re: **Response to Engineering Comments**
 Proposed Residential Development - Half Moon Bay - Phase 8 - Ottawa
to: City of Ottawa - **Ms. Amanda Marsh** - Amanda.Marsh@Ottawa.ca
to: Mattamy Homes - **Ms. Mina Rassa** - mina.rassa@mattamycorp.com
date: May 30, 2018
file: PG2992-MEMO.02

Geotechnical Comments

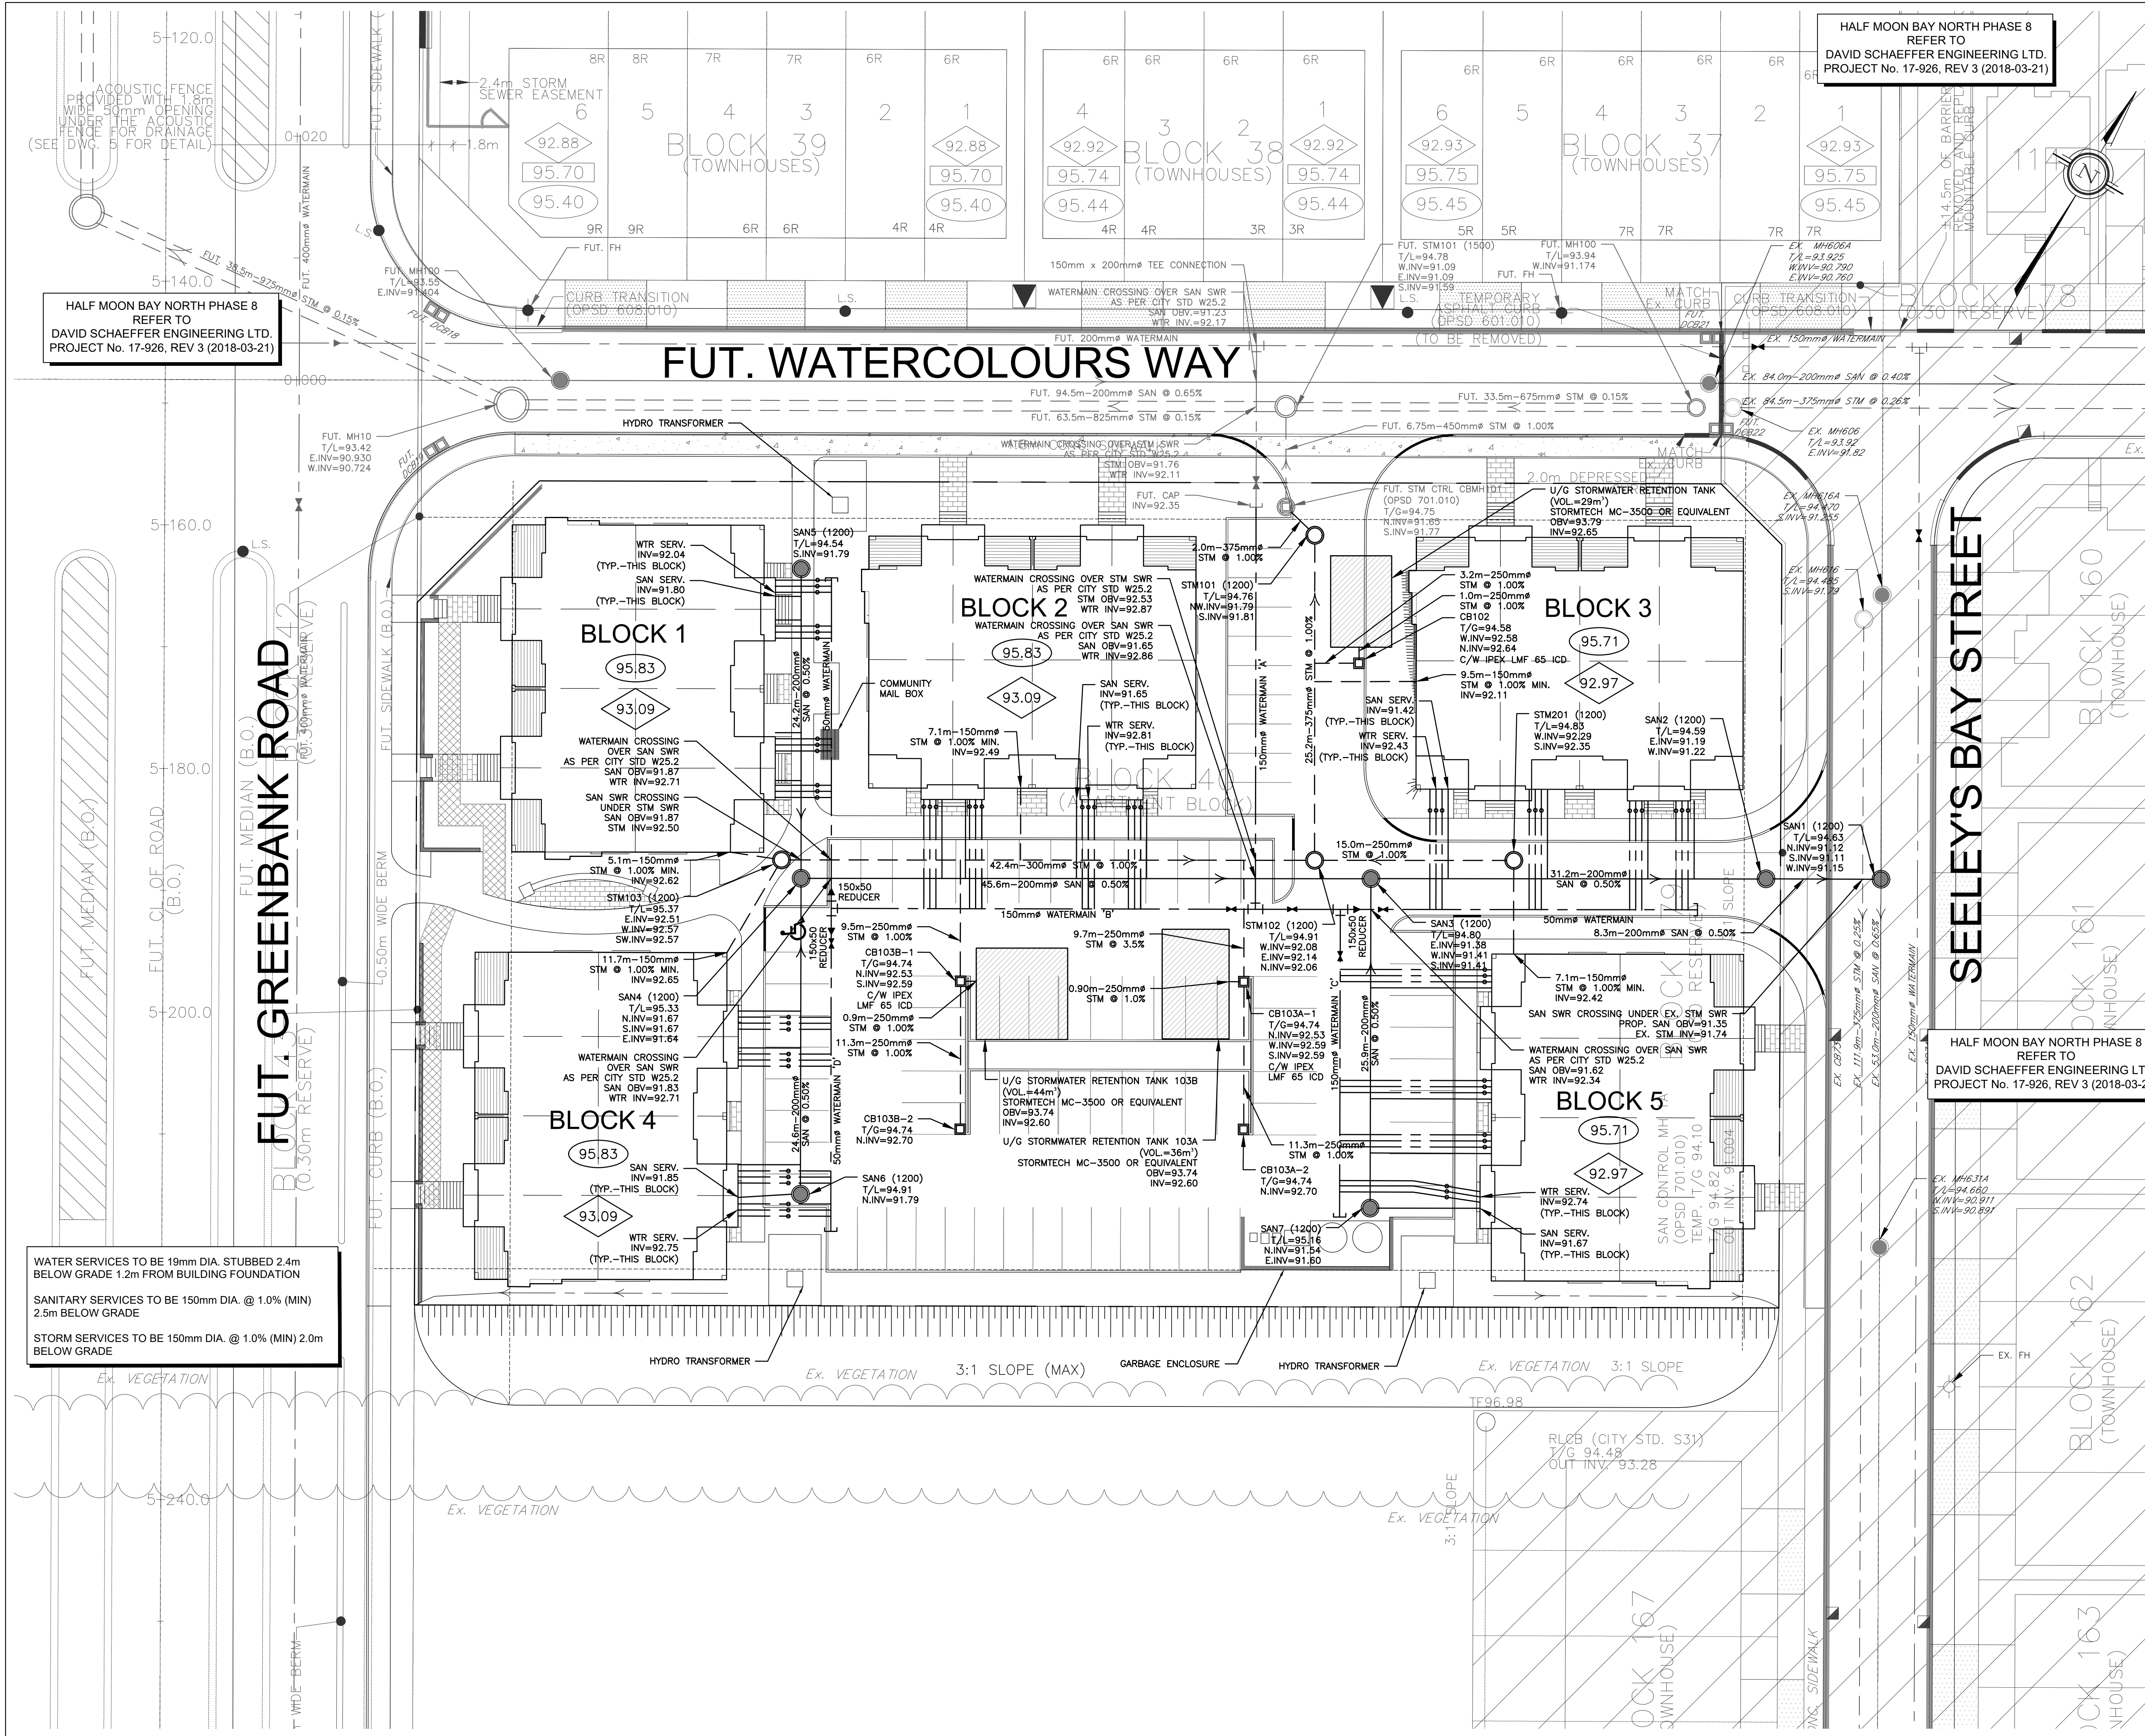
Comment: Confirm if underground StormTech storage is acceptable with regards to groundwater table.

Response: The following servicing plan prepared by DSEL was reviewed as part of our assessment:

- ☐ Project No. 17-987, Drawing No. SSP-1 - Site Servicing Plan Block 40 - Half Moon Bay Phase 8, Revision 1 dated April 3, 2018.

Based on our review of the above noted drawing and the findings of our geotechnical investigation, the invert level of the proposed stormwater retention tanks ranges between 93.19 and 93.26 m while the long-term groundwater level ranges between 89.5 and 91.5 m. The proposed tanks were designed following the City of Ottawa standards where the invert of the stormwater chambers is at a minimum vertical separation of 1 m from the long-term groundwater table. Based on the above, the underground stormwater tank locations and elevations are acceptable from a geotechnical perspective.
